**Rezoning Transportation Analysis**  
**Petition Number: Insert Zoning Petition #2021-213**  
*General Location Identifier: 22706130*

Revision Log:	Date	Revision Log:
	01/21/2022	First Review (WB)
	02/21/2022	Second Review (WB)

REZONING
PETITION

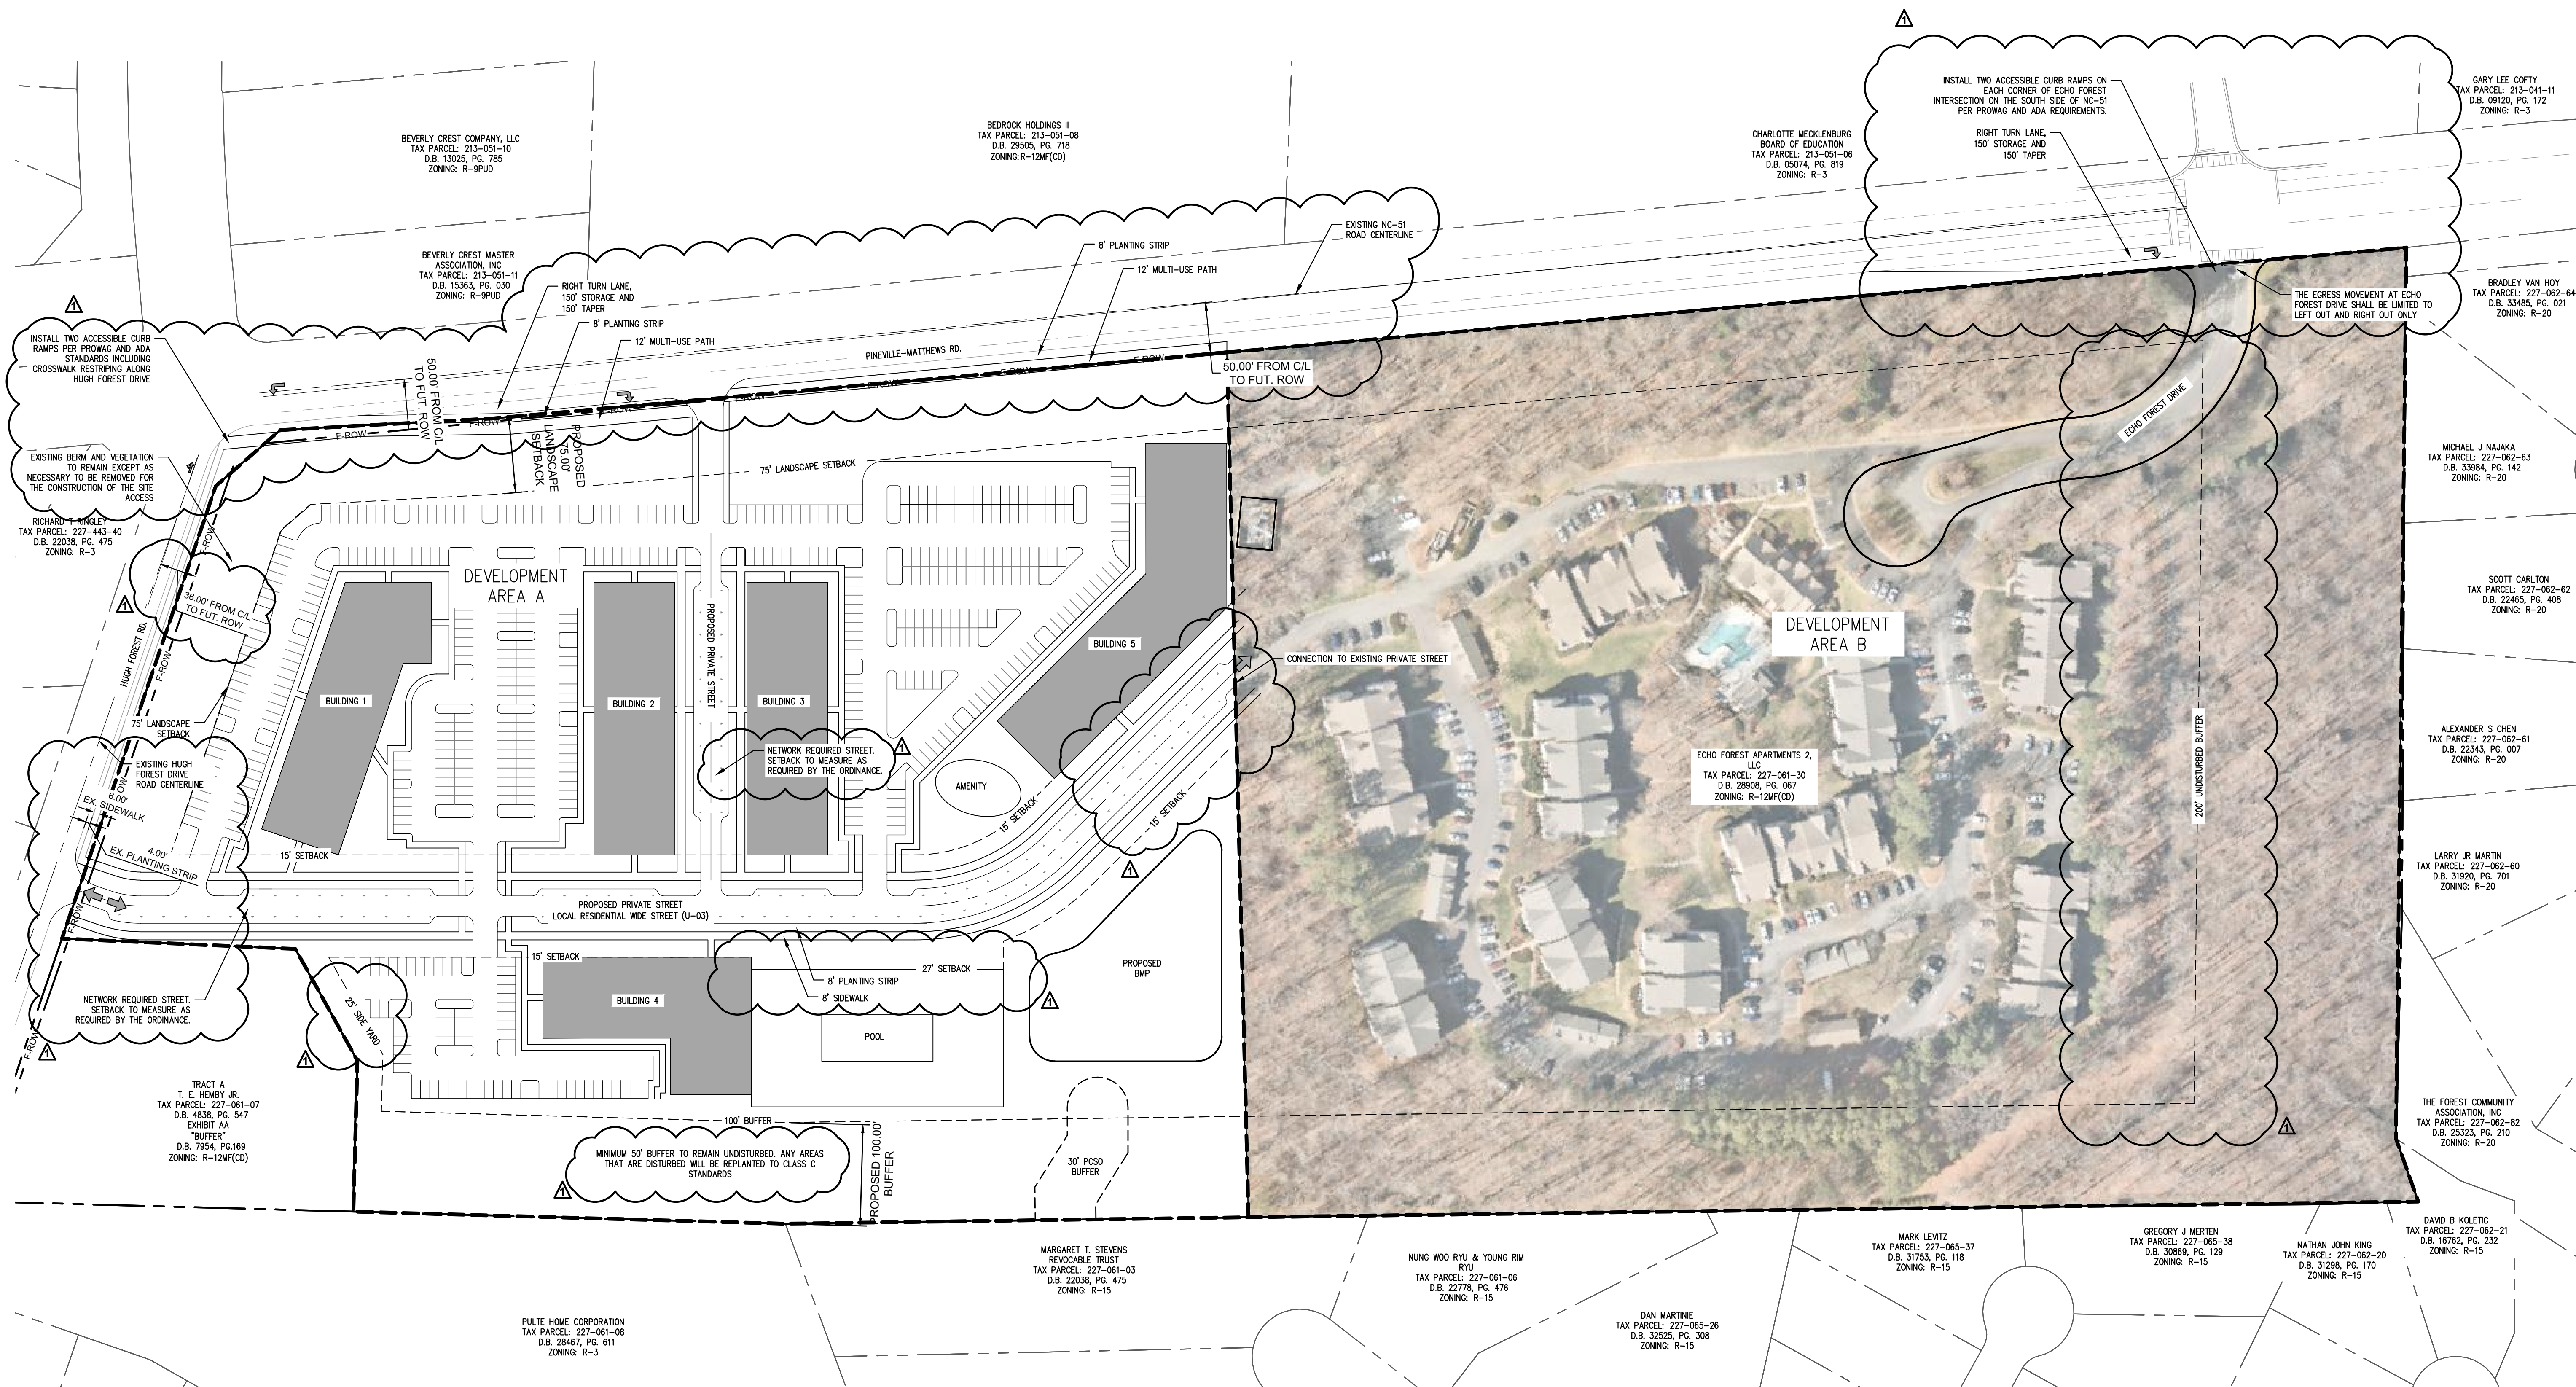
2. Revise site plan and conditional notes to commit to dedicate 50-foot right-of-way from the Pineville-Matthews Road centerline. The site plan shall label and dimension the right-of-way from the road centerline.

3. Revise site plan and conditional notes to commit to dedicate 36-foot right-of-way from the Hugh Forest Road centerline. The site plan shall label and dimension the right-of-way from the road centerline.

5. **Comment Clarification** (Site plan reviewed on 2/21/22): Site plan and conditional notes revisions are needed to commit to construct bicycle facilities by installing a 12-foot multi-use path along the site's entire Pineville-Matthews Road frontage in accordance with the Charlotte BIKES Policy. The site's frontage includes both Area's A and B.

9. The egress movement at Echo Forest Drive shall be limited to 'left out and right out' only to mitigate the increase in traffic at the existing signalized intersection. No northbound through movements will be encouraged. Petitioner to install a concrete channelization island per NCDOT standards to enforce the restricted movement.  
*NCDOT will require a concrete island installation during permitting.*

11. **New Comment** (added on 2/21/22 to address sight distance concerns): Petitioner to provide Intersection Sight Distance (ISD) at proposed driveway access points. ISD must be shown in both horizontal and vertical dimensions (plan/profile) along the sight line, not the roadway centerline. The horizontal dimensions (plan) shall include contours corresponding with the vertical dimensions (profile).

12. **New Comment** (added on 2/21/22 to address traffic concerns): Petitioner to provide passenger car and truck turning movements for U-turns movements made on Pineville-Matthews Road at the Hugh Forest Road intersection.

Correct Conditional Transportation Note 3.i to dedicate 50-foot of right-of-way to NCDOT.
